From: MIKE MURRAY [REDACTED]
Sent: 21 June 2018 07:45
To: Planning.Responses
Subject: Re: Please find attached details of Planning decision on Application Ref: FG/42/18/HH

APPLICATION FG/42/18/HH
NO:

Site 17 Foamcourt Waye Ferring BN12 5RD
Address:

Description of Works: Demolition of existing detached garage & rear conservatory, enlargement of existing driveway, single storey side extensions, extension of existing roof over proposed extensions with 5 No. dormer windows.

PROPOSED ROOF PLAN

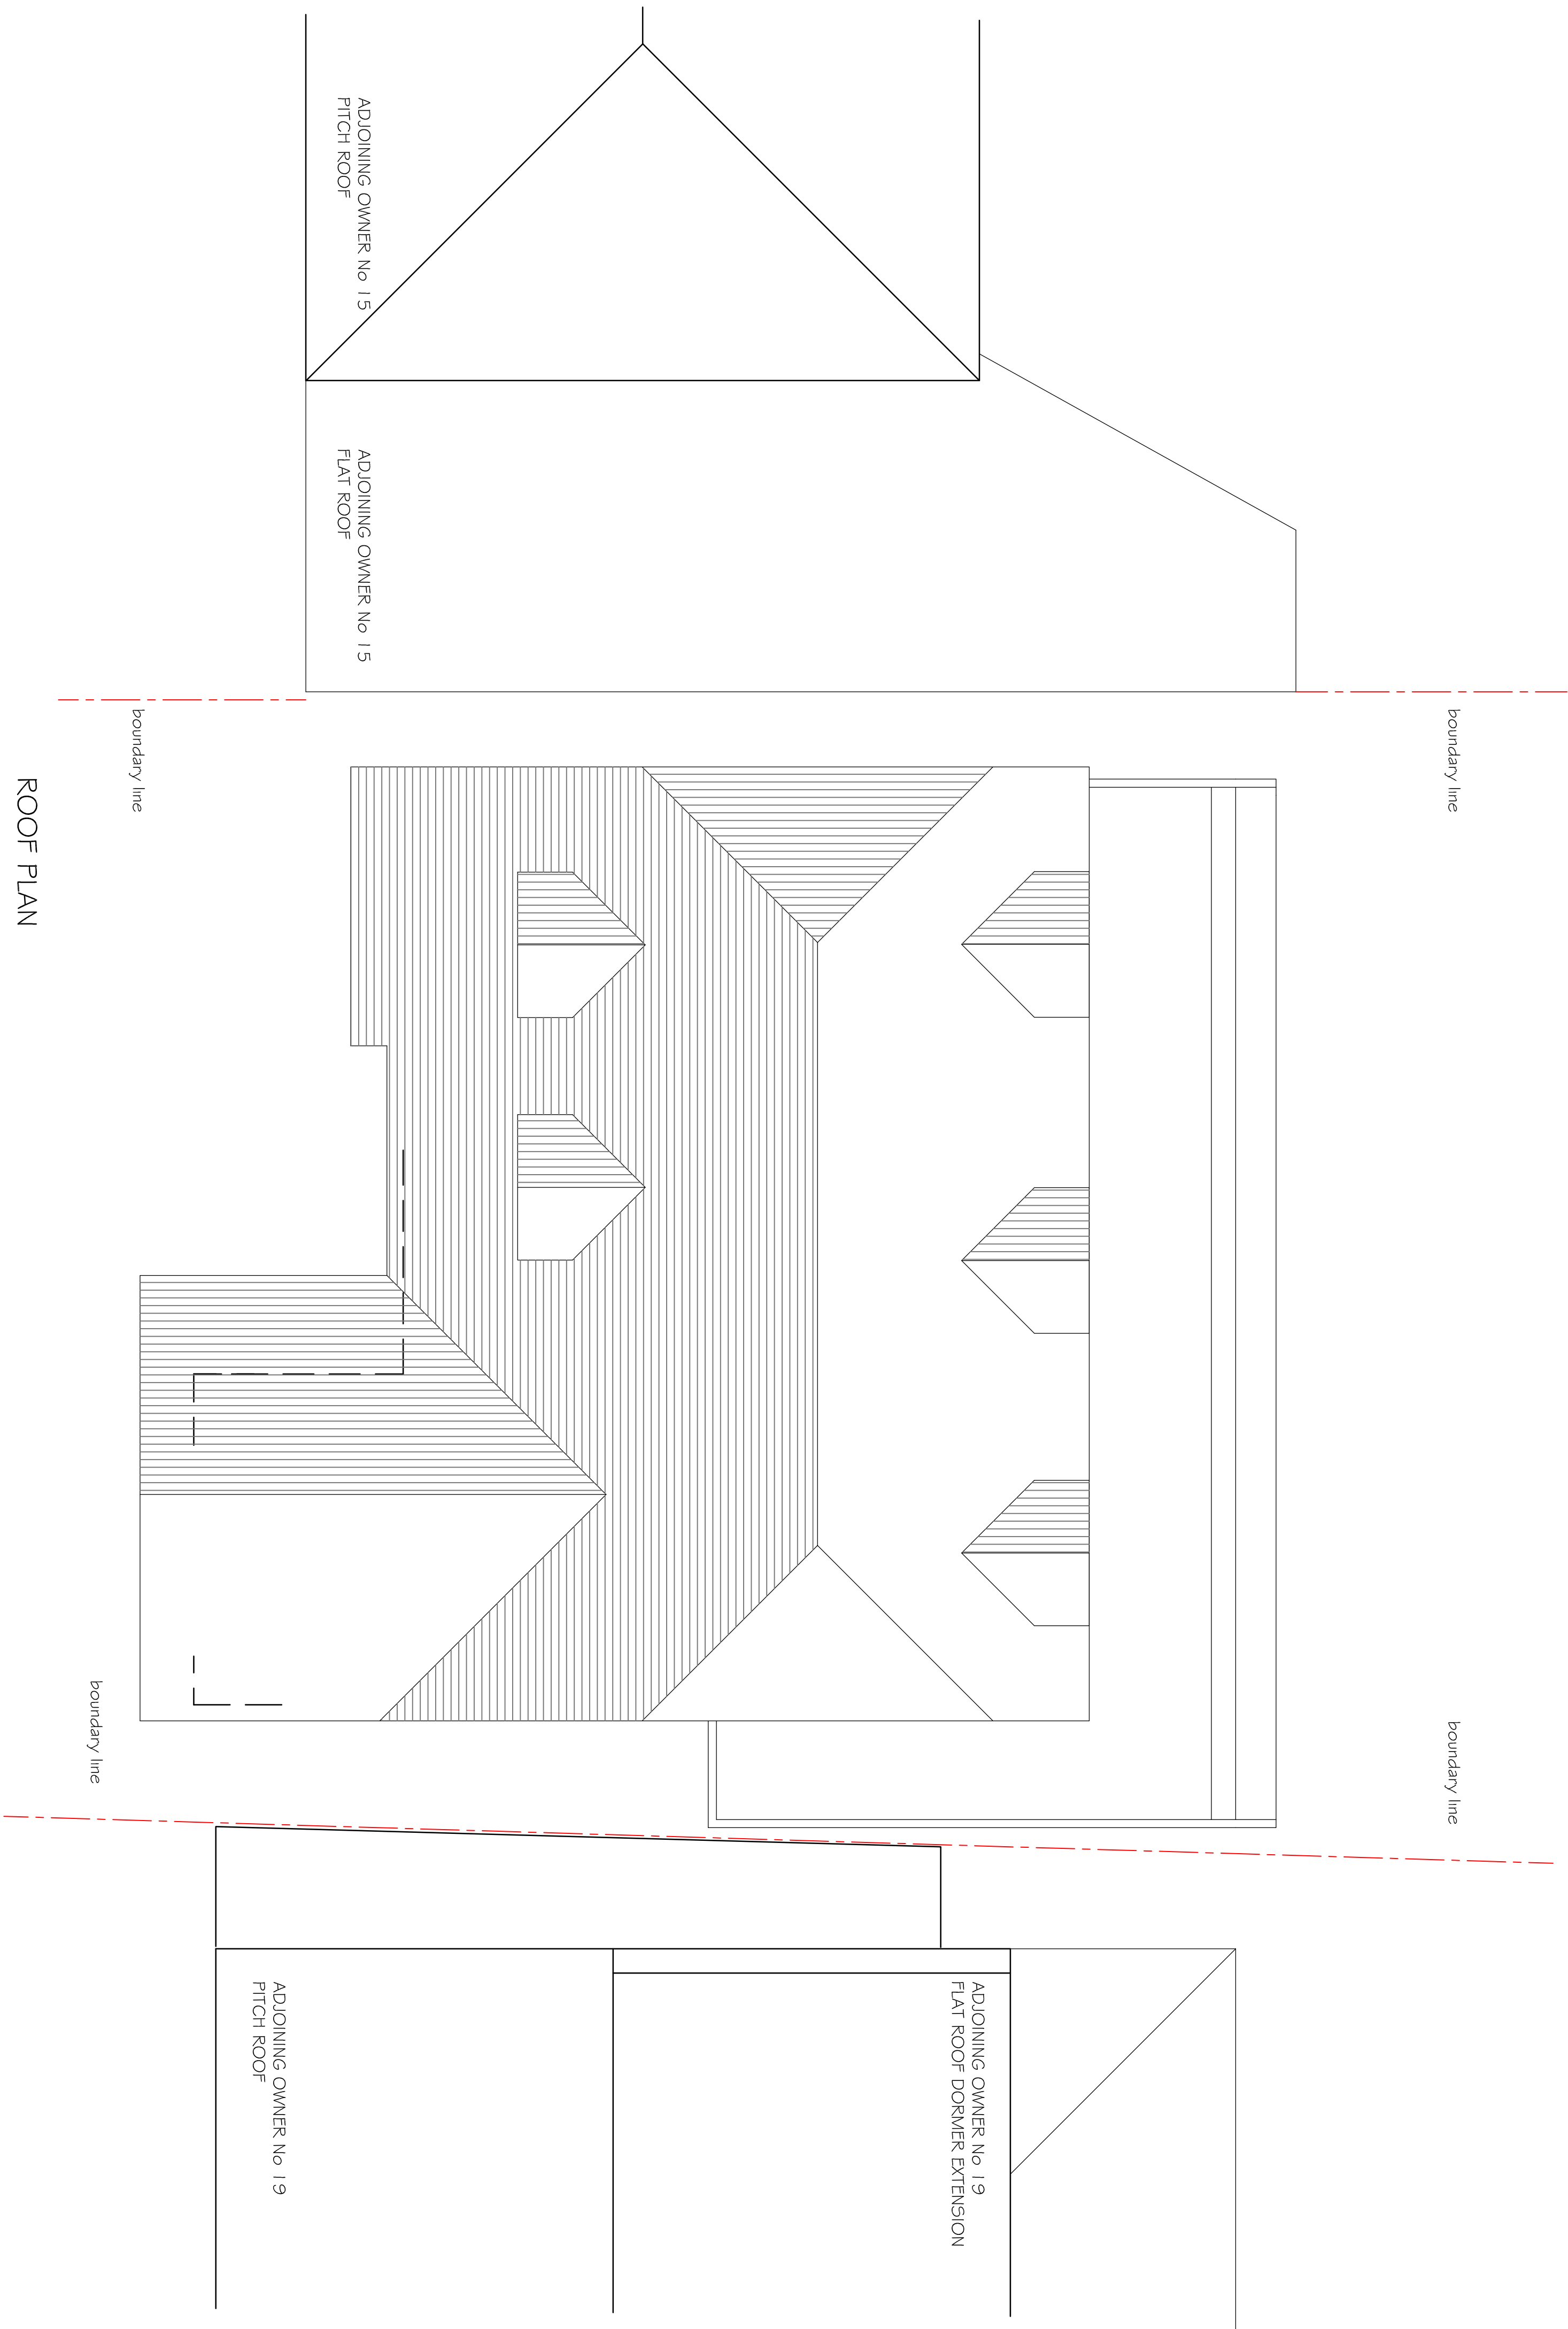
The comment 'not result in an unacceptable loss of space about building' is again factually so wrong. The roof is going to be 'approximately 1.2m' higher, the ridge 4 times as long, meaning the roof is going to be twice its current size. Such a huge area of sky to the above and sides of the building ARE GOING TO BE LOST. I am really mystified how that conclusion could be made.

Title		PROPOSED FRONT AND REAR ELEVATIONS	
Scale	1:50 at A1	Dwg. No.	**C.C.P.P.** A B
Date	NOV 2017		
Drawn By	SP		
CAD_ref

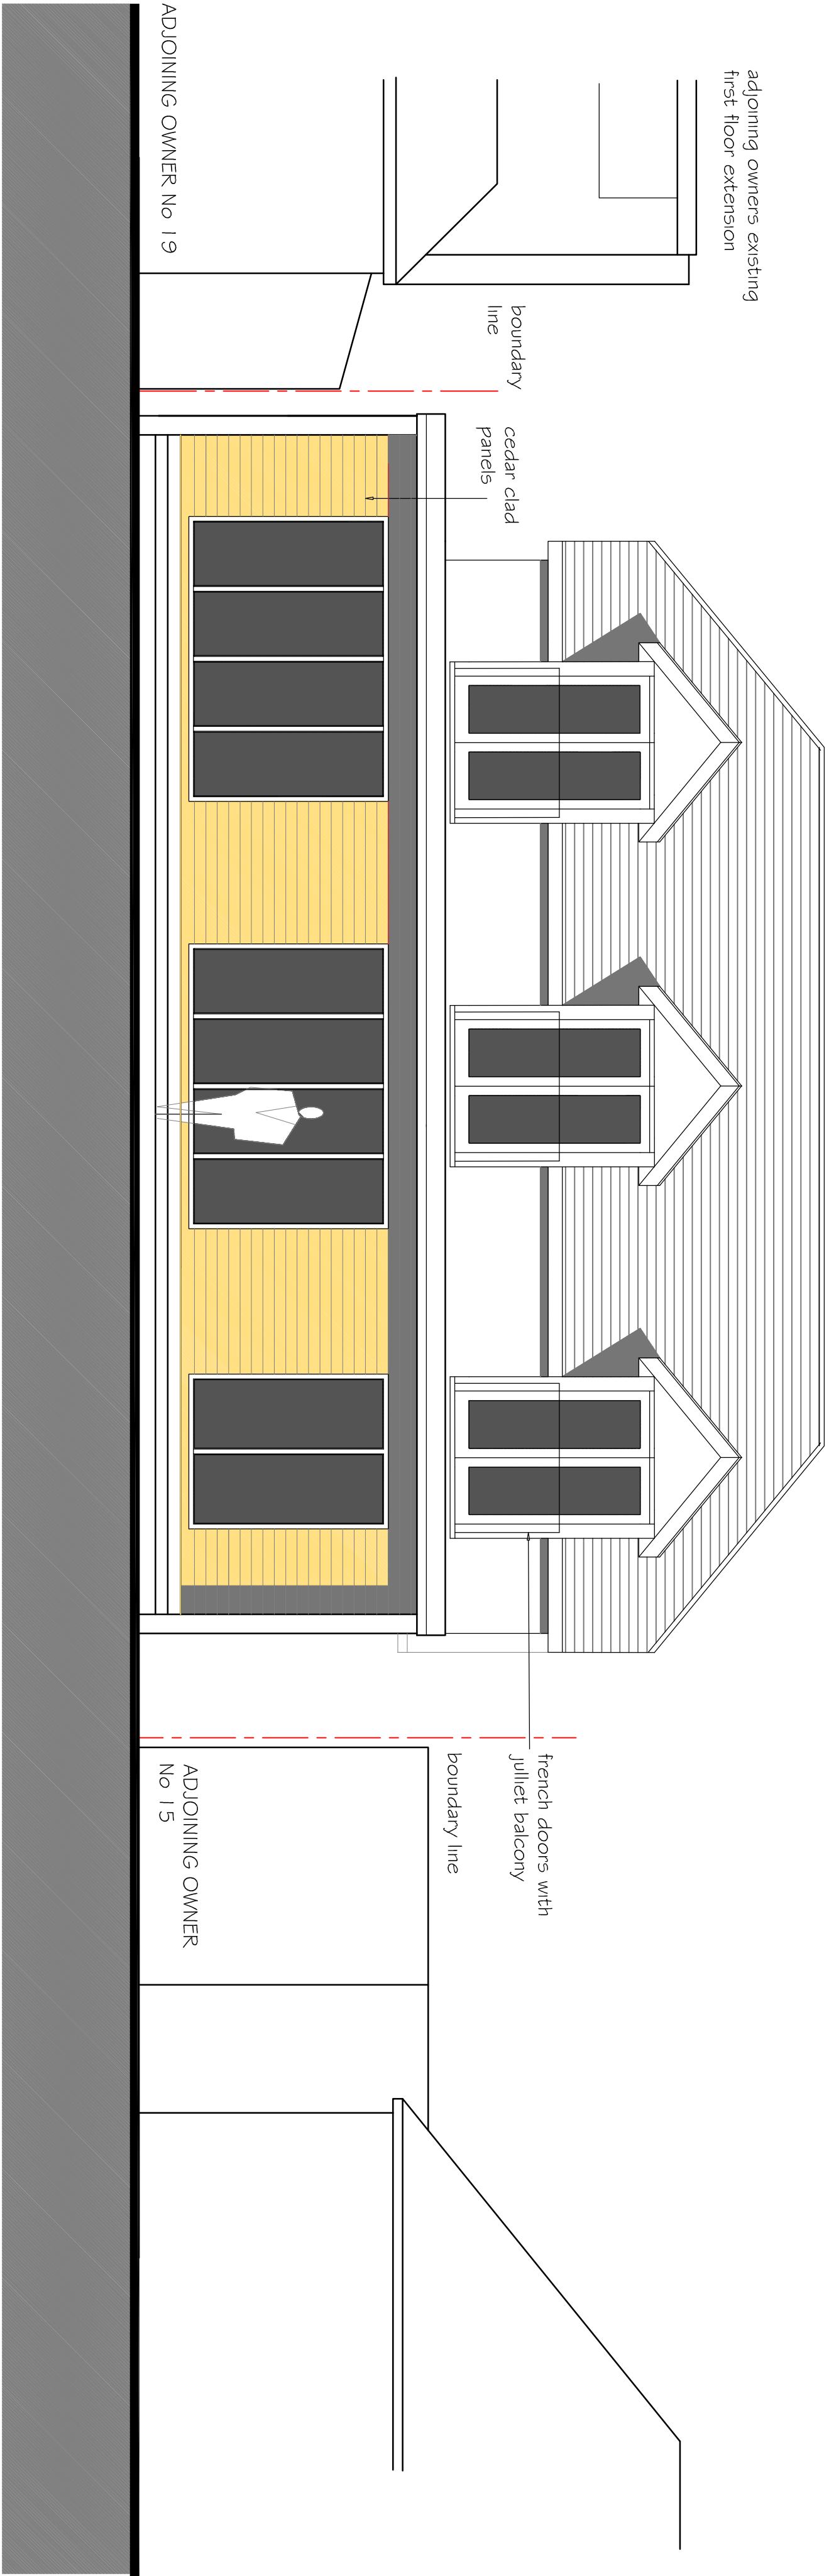
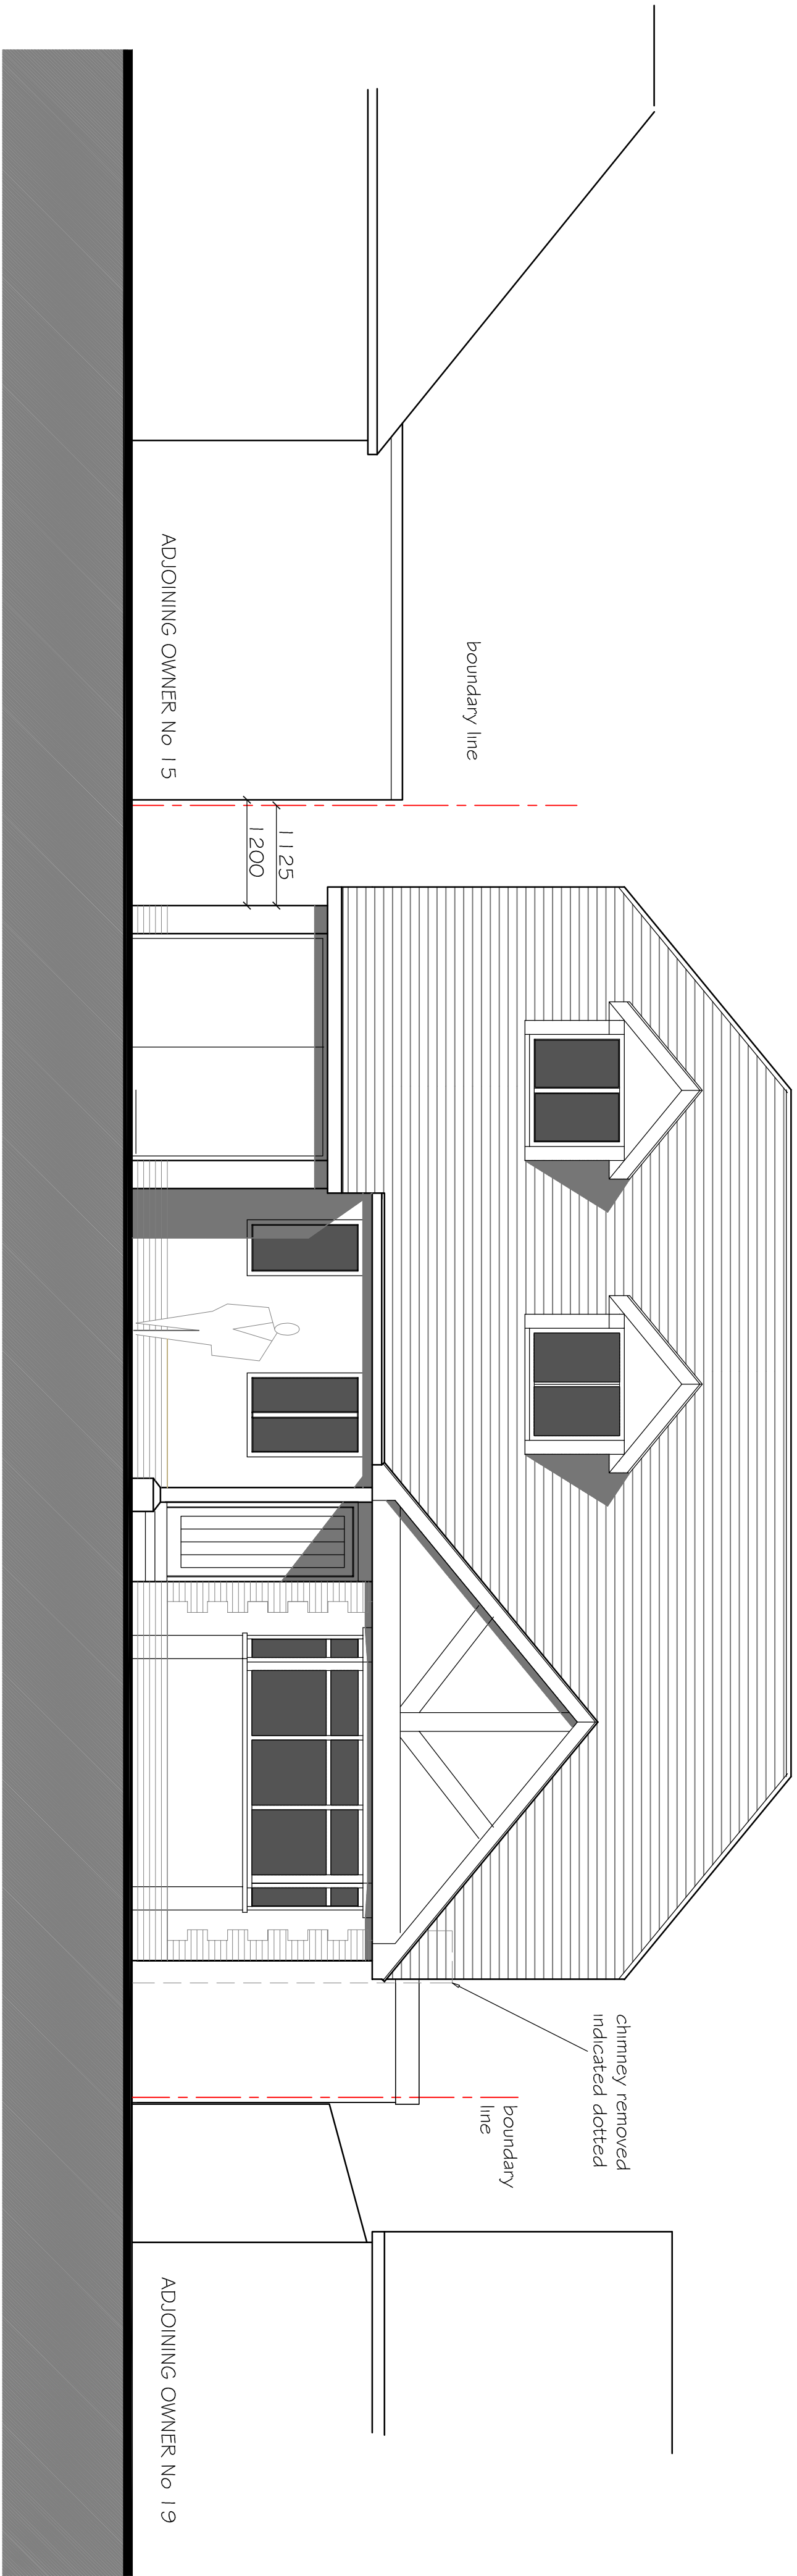
- Three of us will now loose between 15 and 30 minutes of direct sun light every evening.
- There will be a loss of sight of trees and vegetation from the front of properties,
- There will now be two new dormer windows looking onto bedrooms and lounges of three properties opposite.
- The sky will be completely obliterated from one of my lounge windows now.
- The enlarged parking area will have an adverse effect on street scene.
- Juliet windows/balcony will reduce privacy to neighbours property as will overlook garden.

I note the applicant states that the roof is going to be raised by approximately 1.2m, how high you will let him go, given the inaccuracy in parking spaces, 1.5 m, or 1.75 m or even 2.5m. How will this be policed?
